PLANNING CONSULTATION RESPONSE

Application No	2026/0374
Proposal	Erection of a detached 2 storey dwelling and associated works
Address	49A Rowland Road, Old Town, Barnsley, S75 2PF
Date of Consultation Reply	07/09/26
Consultee	Highways DC

Title
Proposed block plan

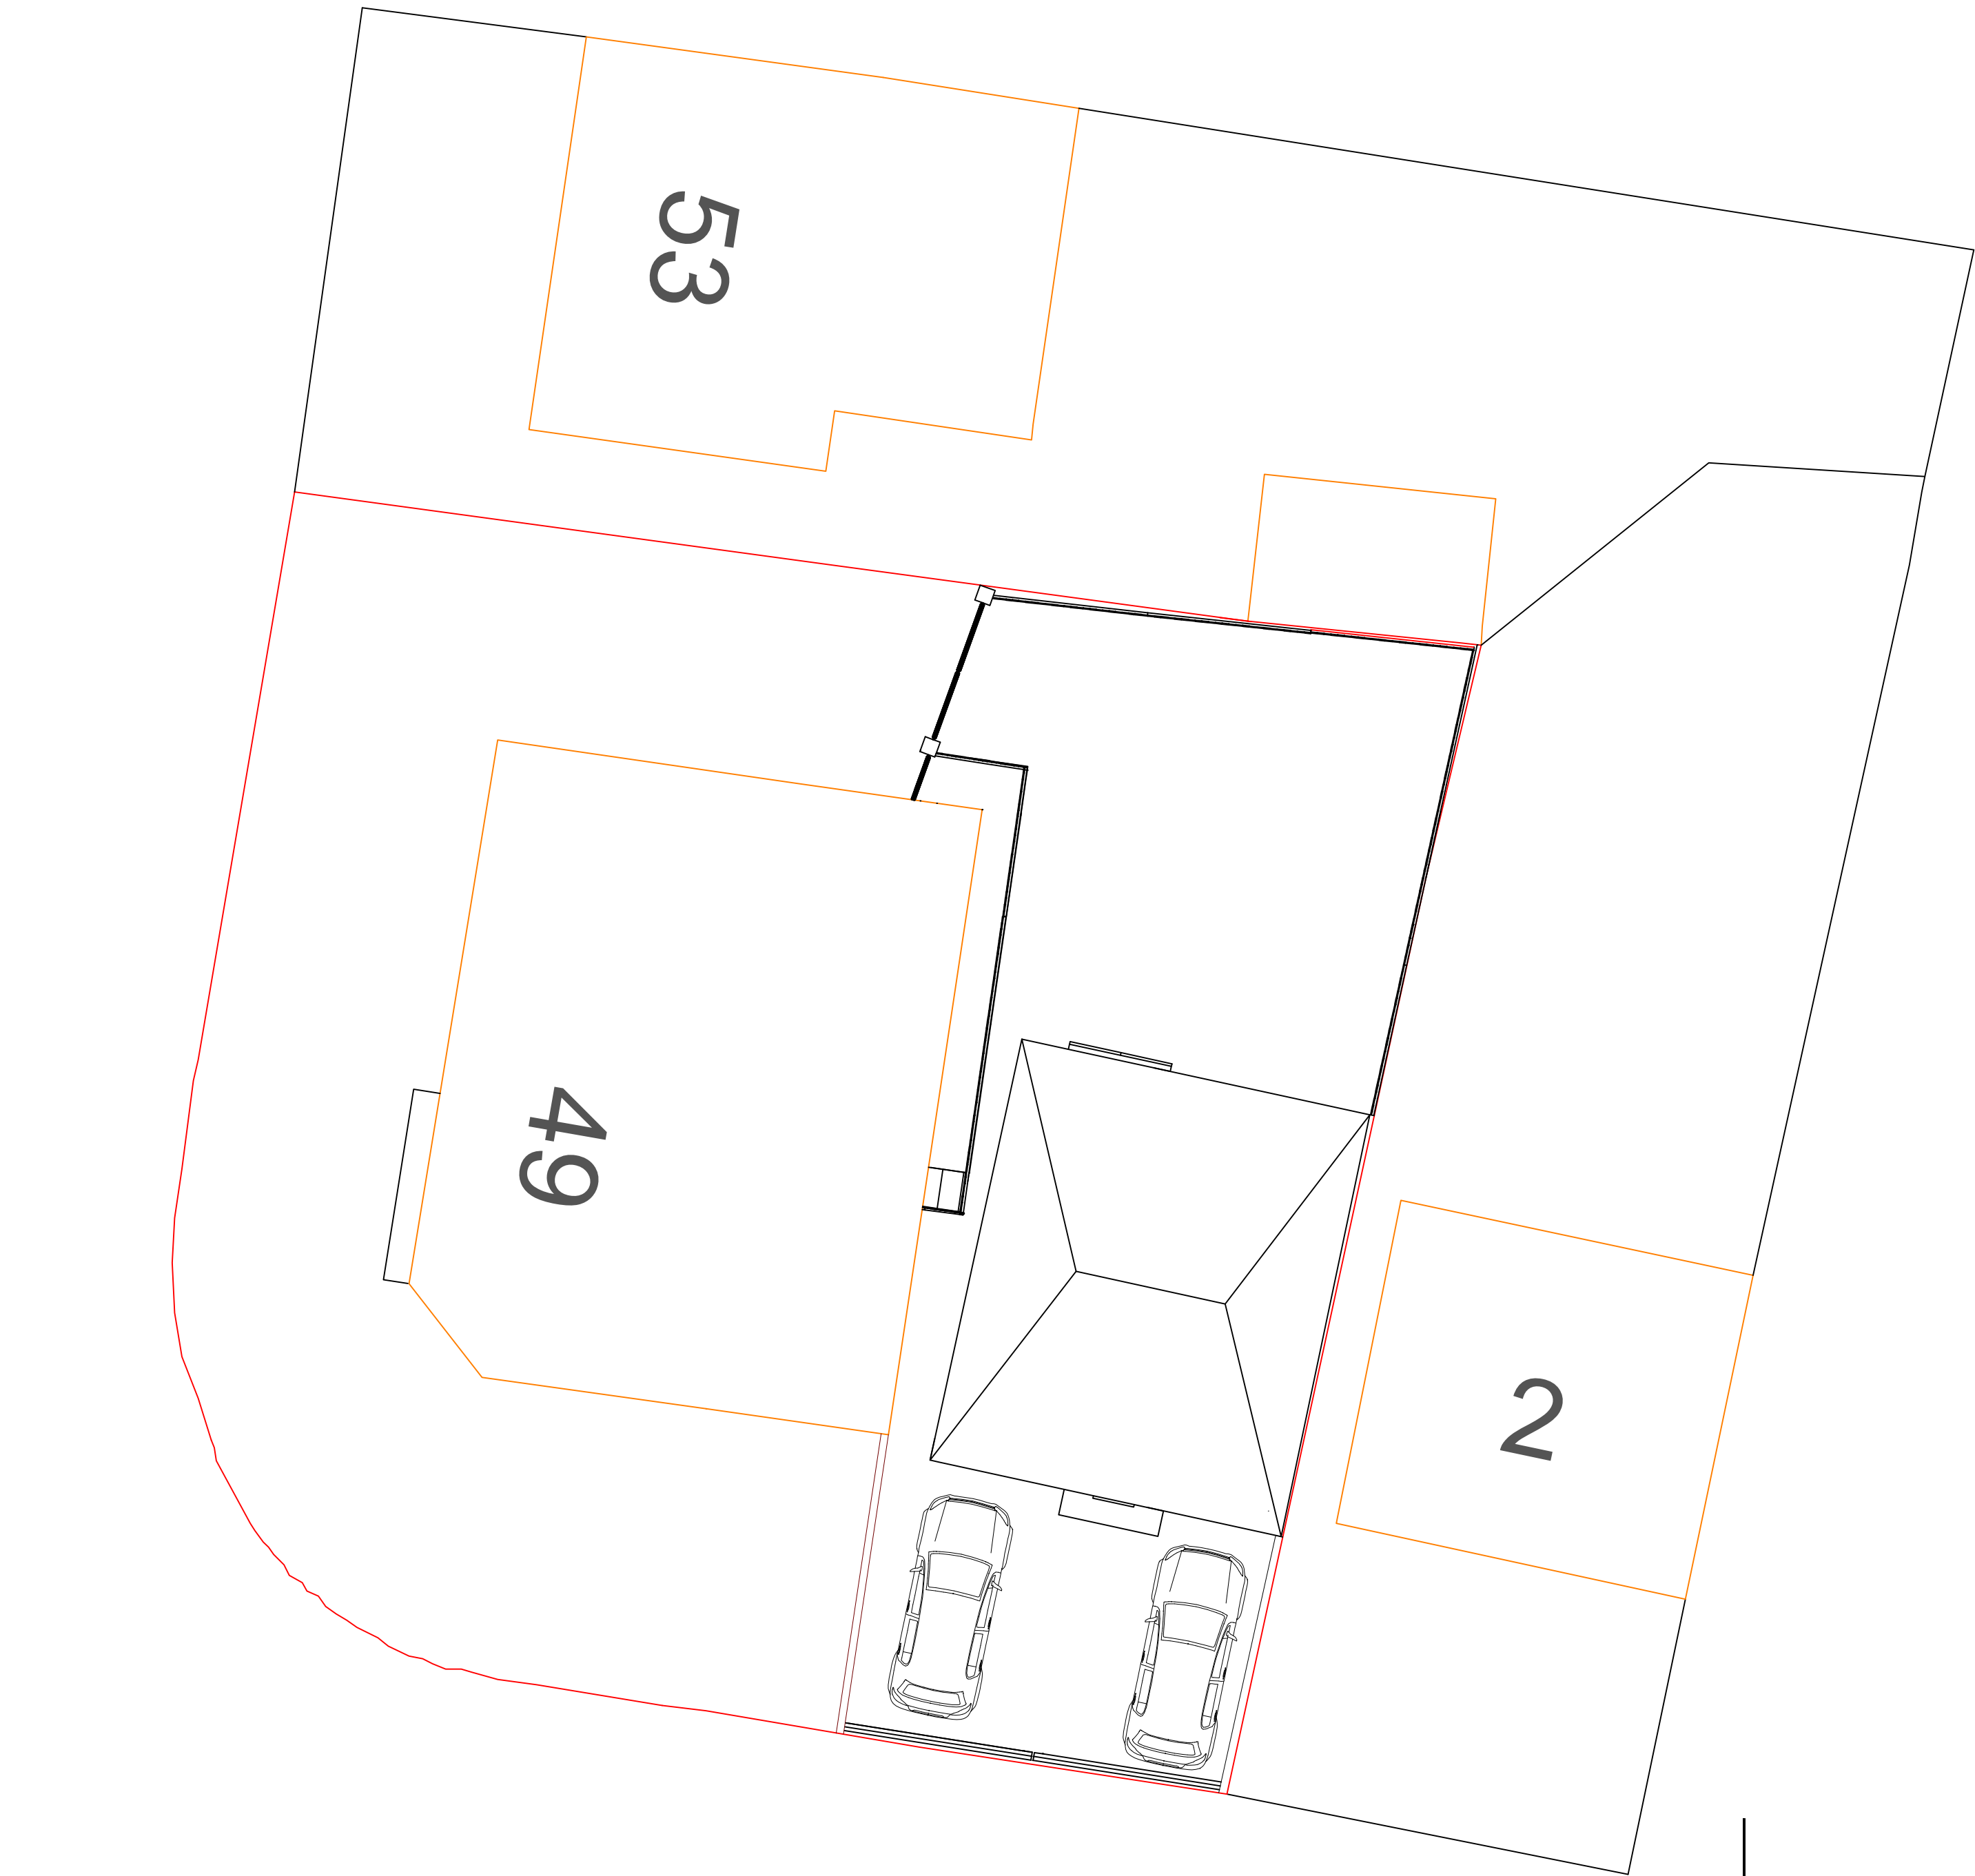
The Council's Parking SPD recommends two off-street parking places are provided for dwellings with three or more bedrooms. The submitted layout plan shows that two spaces are to be provided for the dwelling, and the scheme therefore follows the council guidance.

As the proposals provide off-street parking to an acceptable level, HDC officers would have no wish to raise objection to the scheme. However, there are no details of refuse storage or collection pads demonstrated on the submitted layout drawing, nor has any specific secure cycle storage been shown. As such, it is asked that the below conditions are added to any decision notice.

The parking facilities as indicated on the submitted plan shall be surfaced in a solid bound permeable material (i.e. not loose chippings) and adequate measures shall be so designed into the proposed access to avoid the discharge of surface water from the site on to the highway.

No works shall commence on site until a scheme for the parking of bicycles complying with LTN 1/20 Cycle Infrastructure Design has been submitted to and approved in writing by the Local Planning Authority. The scheme shall be fully implemented before the development is first occupied (or brought into use) and thereafter retained for this purpose.

Before development commences, details of suitable storage, bin presentation points and access for collection of wastes from the dwellings hereby approved shall be submitted to and approved in writing by the Local Planning Authority. The approved details shall be provided before first occupation and shall be so retained thereafter.
